RE: MP09_0066 MOD 10 – THOMAS STREET CAR PARK SITE CHATSWOOD (Our ref. S090002)

Reference is made to the Department's advice of lodgement of Modification 10 to MP09_0066 by Karimbla Construction Services (NSW) Pty Ltd for variation of the approved development to address illuminated signage on proposed Building 2 (serviced apartments) in the development currently under construction.

LEVEL 32 PLAN

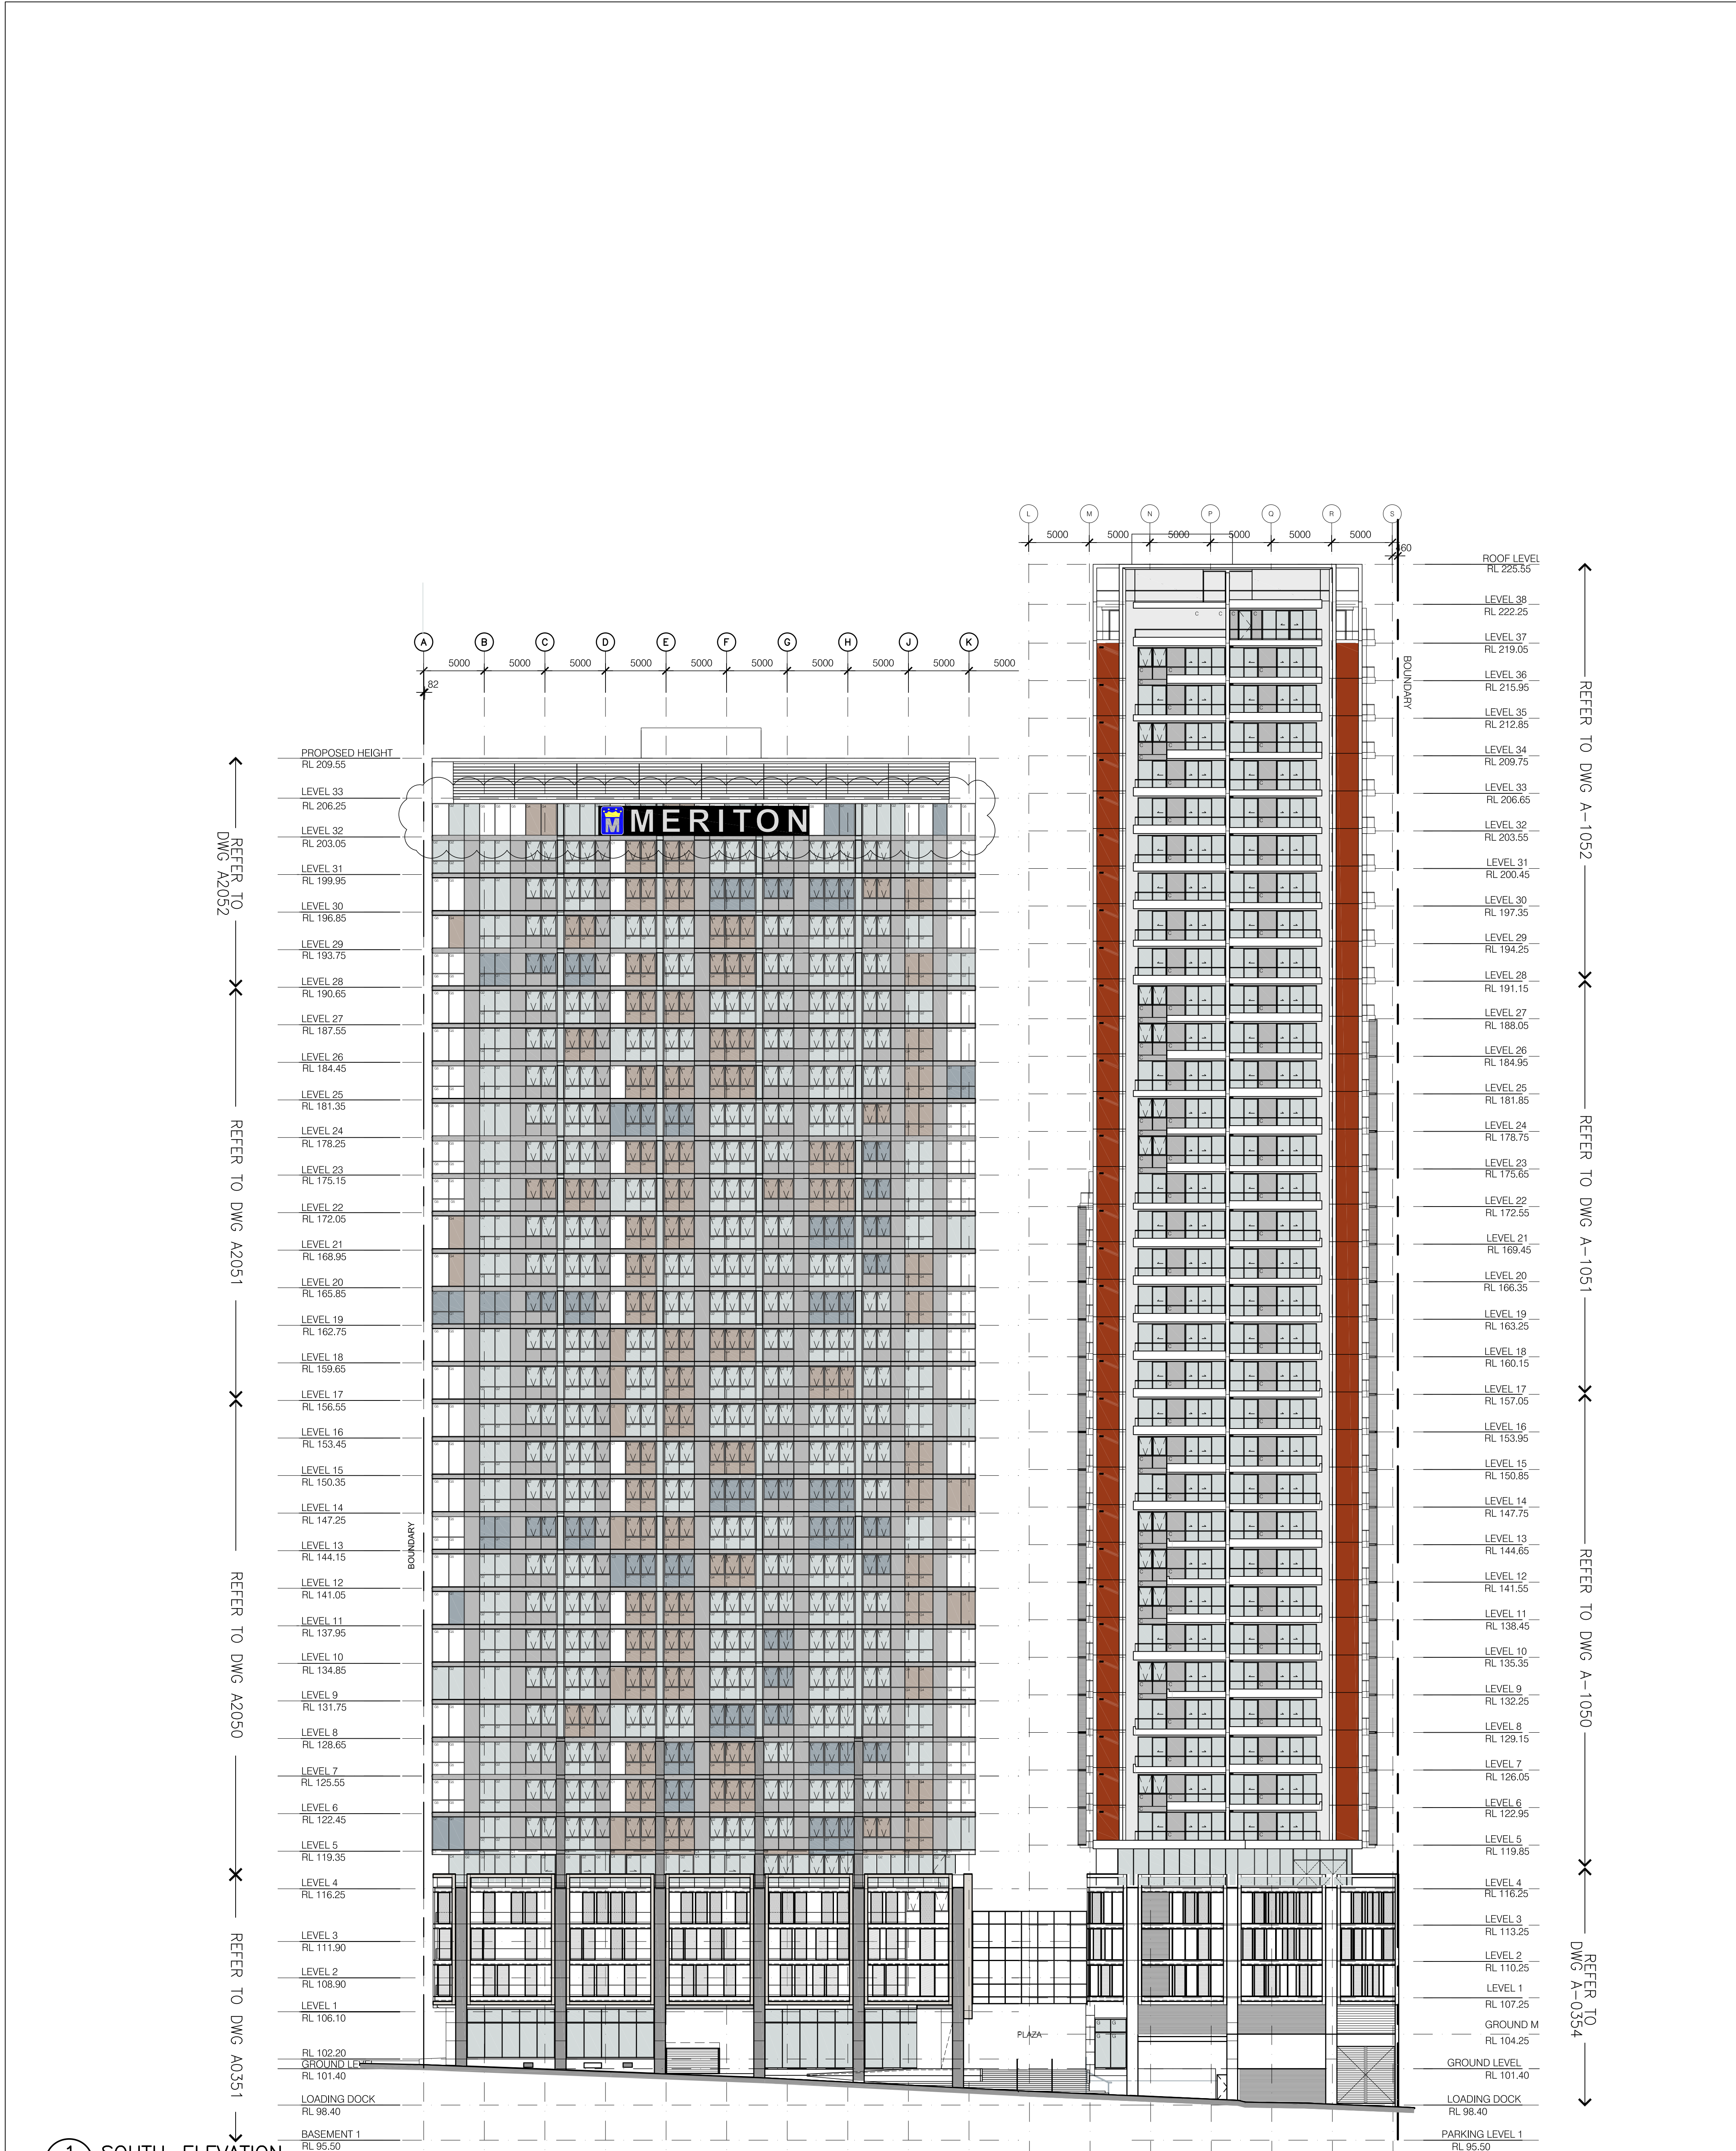
Also not clear from the application is the fact that to provide the signage of the dimensions proposed on the southern façade requires an increase in height of the glazed façade and parapet overhang at Level 32 to accommodate the proposed south facing sign.

SOUTH-ELEVATION

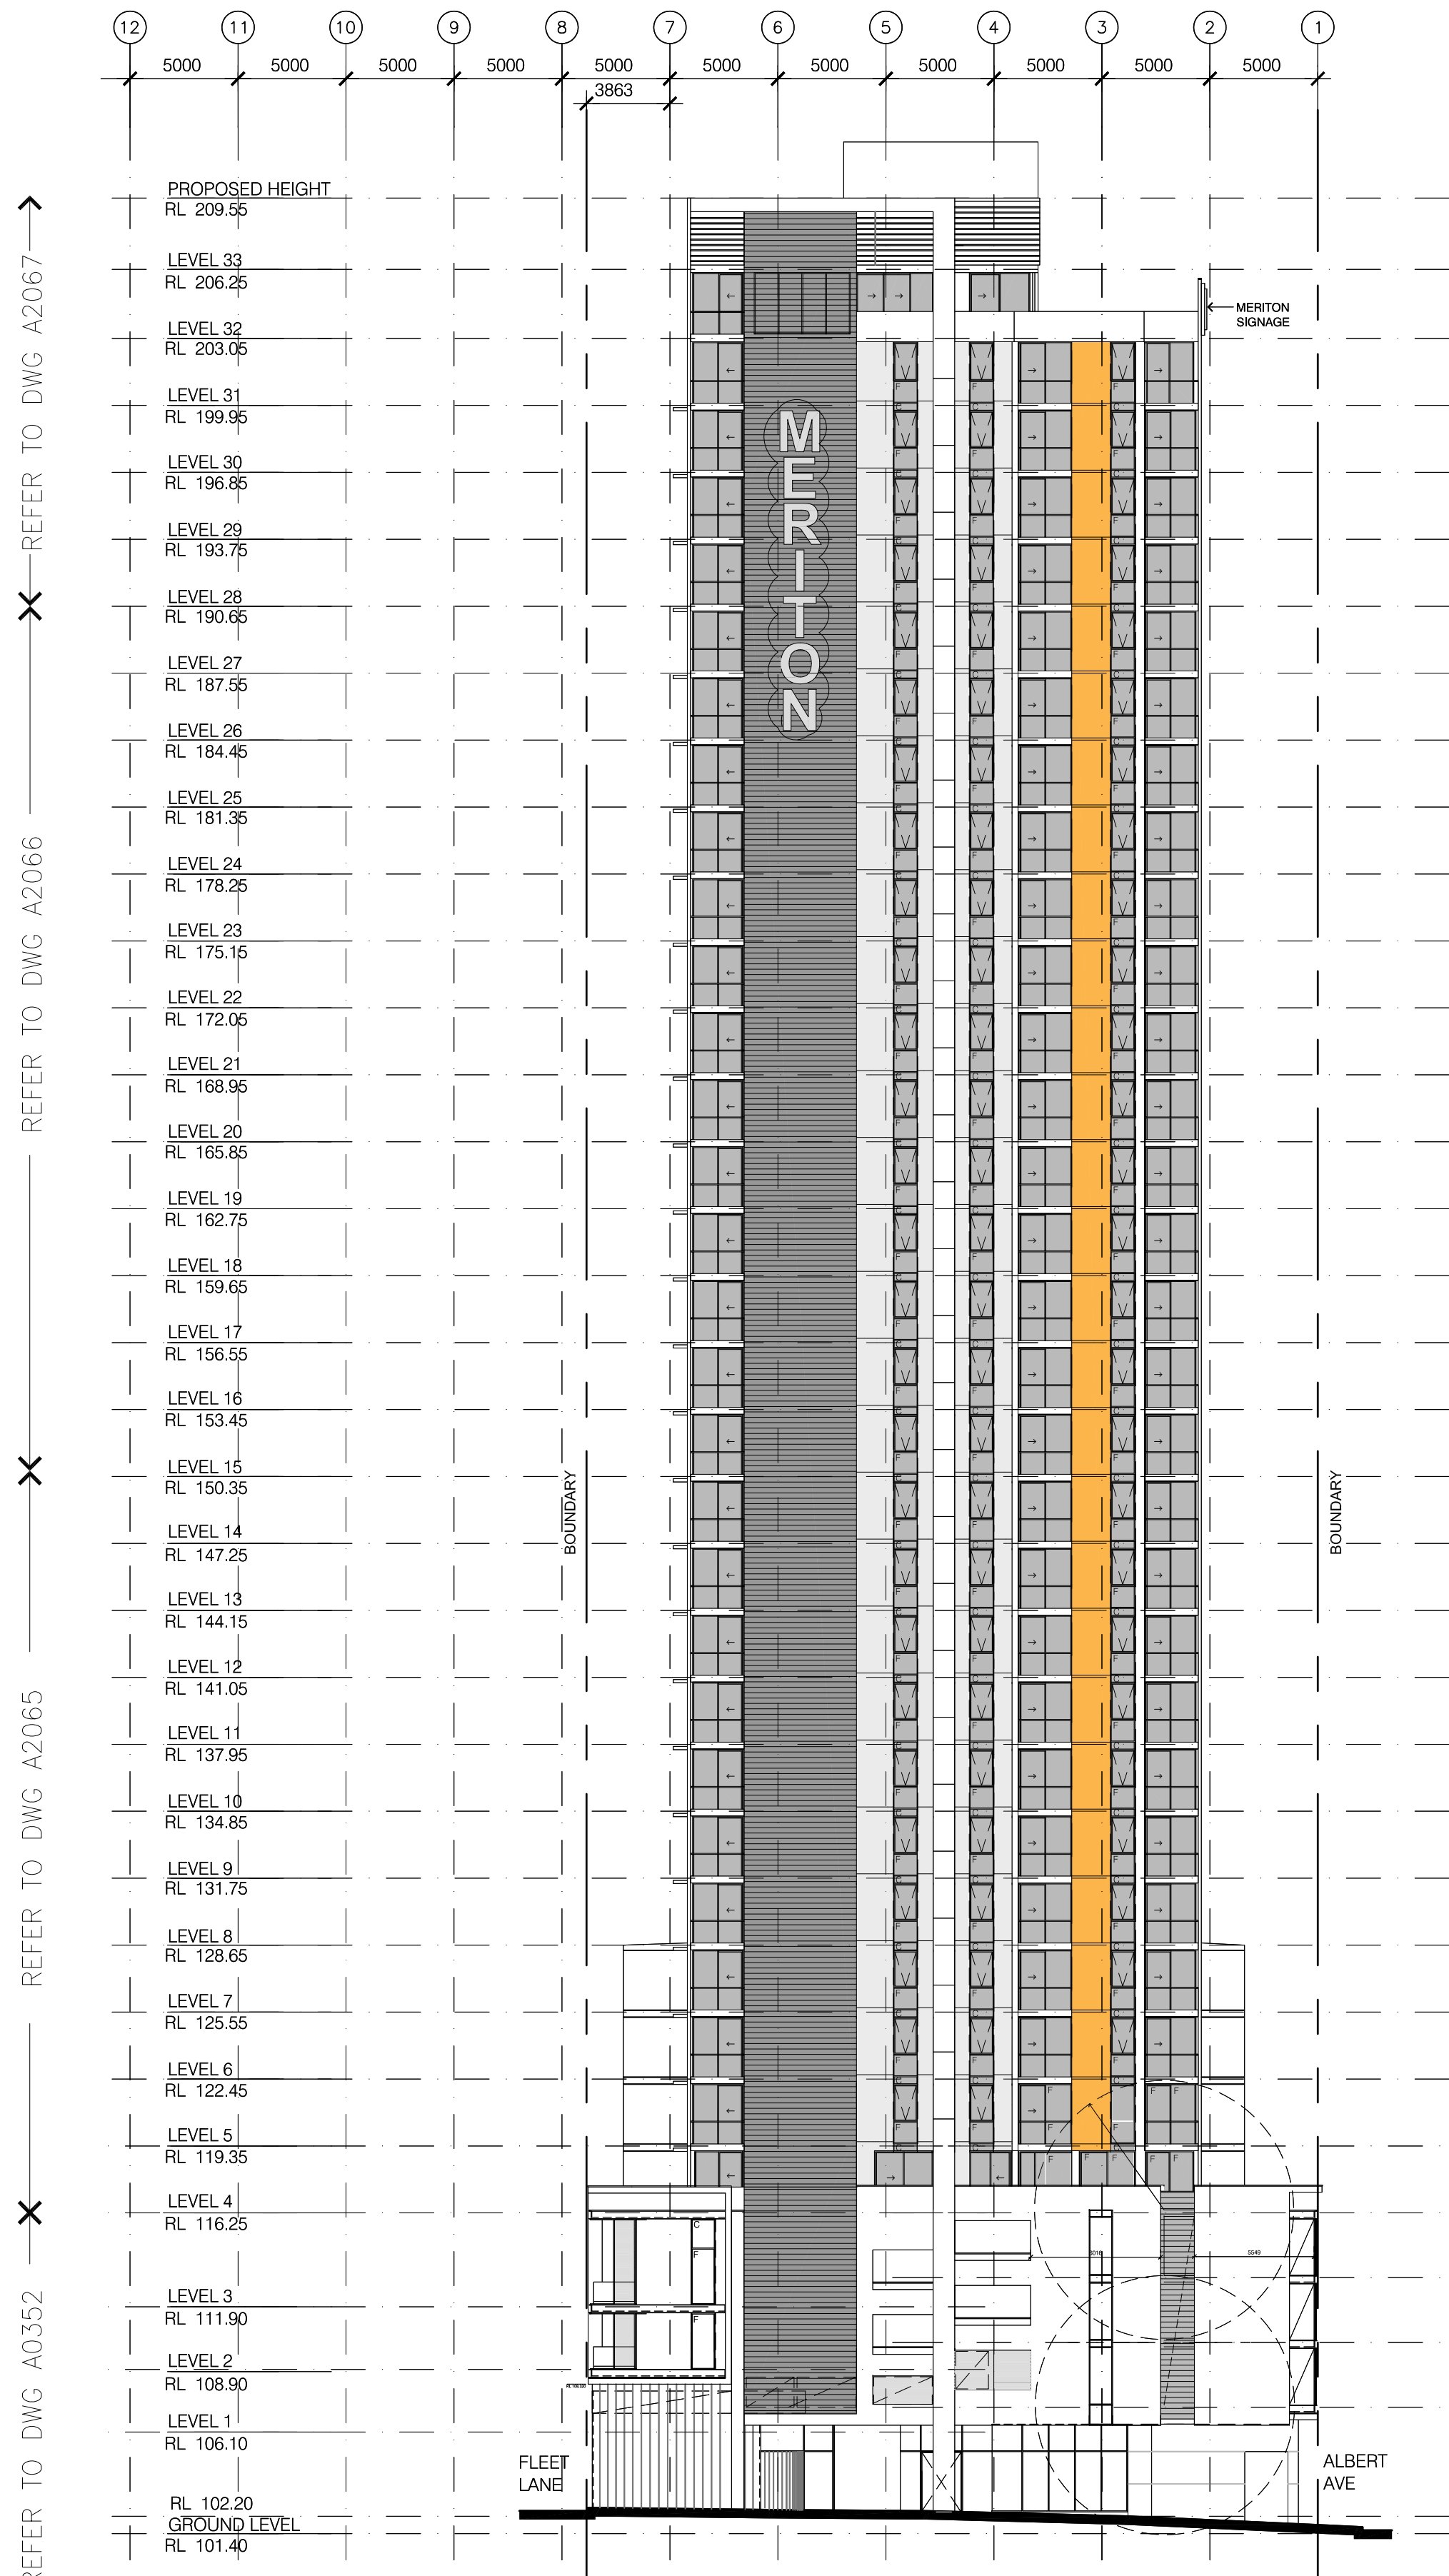
Although not clear in the application, the proposed amendment is for provision of two "business identification signs" for Meriton that will operate the service apartment complex located in Building 2. The modification proposes an additional sign on the western elevation of Building 2 and the relocation of the approved signage location on the southern elevation from the façade of the plant room at Level 33 to the façade at Level 32.

Council has no objection to the west facing vertical sign. However, Council objects to the relocation of the proposed sign on the southern elevation. Council considers that the south facing sign should remain in the approved location on the building façade at Level 33 affixed to the plant room façade. This will allow the signage to be recessed on the façade of the plant room similar to the other tower signs in Chatswood rather than the sign being positioned on the primary elevation. This will also avoid the need to vary the height of the building façade and parapet across the southern elevation and to ensure architectural integration with the approved built form. This is consistent with the DCP. The decision granting consent to the approved development was critical of the overshadowing caused by the tower. Retaining the south facing signage on the recessed plant overrun will maintain the approved shadow impact of the development. Level 33 is set back from the main façade of the building but still provides prominent visibility to the south, west and east.
